Application for a non-material amendment following a grant of planning permission.

Additional personal door added to Units 1, 2, 3 and 8

UNIT 1

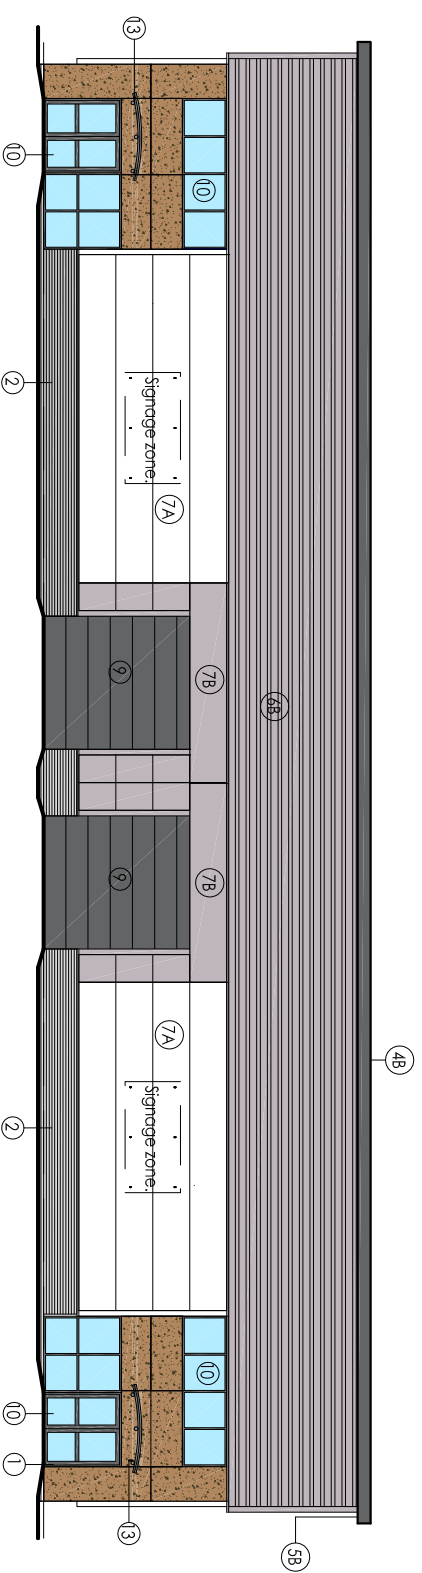
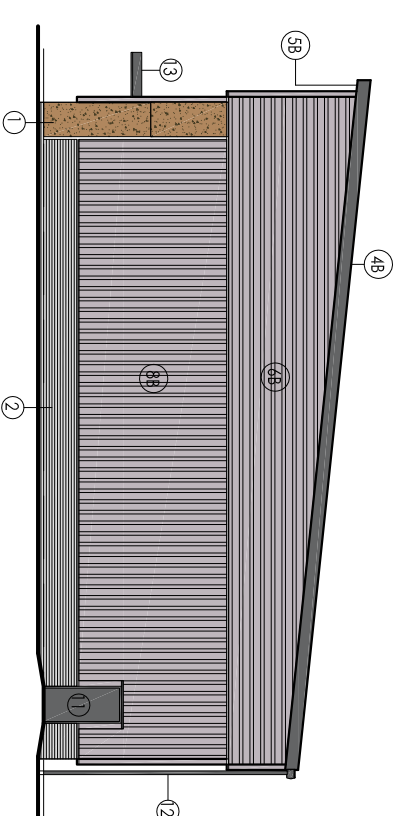
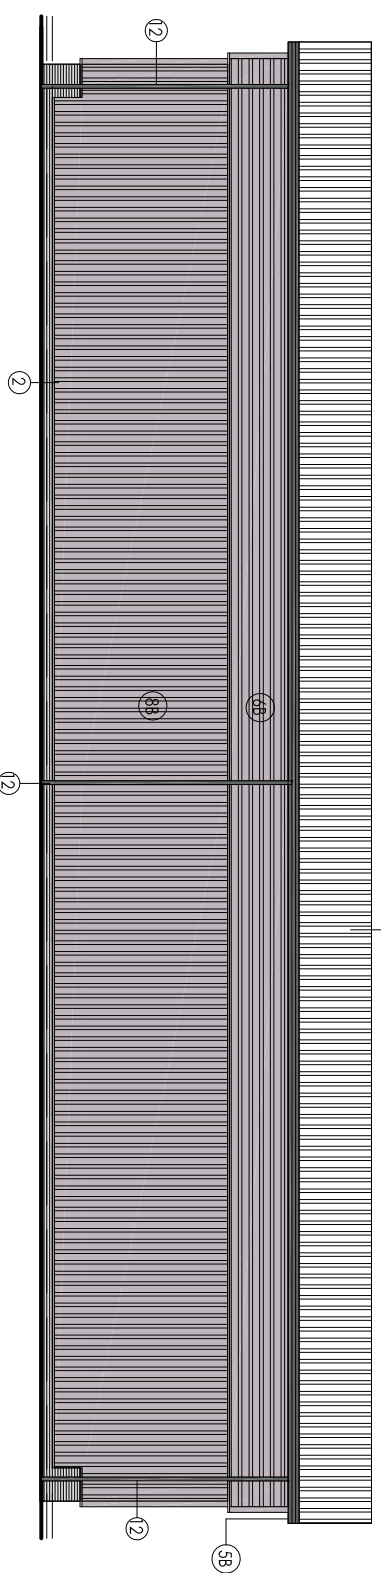
For staff to use the proposed personal doors rather than the sectional doors, for safety

11548(D)02H Unit 1 @ A1 19-09-18
11548(D)03G Unit 1 @ A1 19-09-18
11548(D)04K Unit 1 @ A1 19-09-18
11548(D)10E Unit 1 @ A1 19-09-18
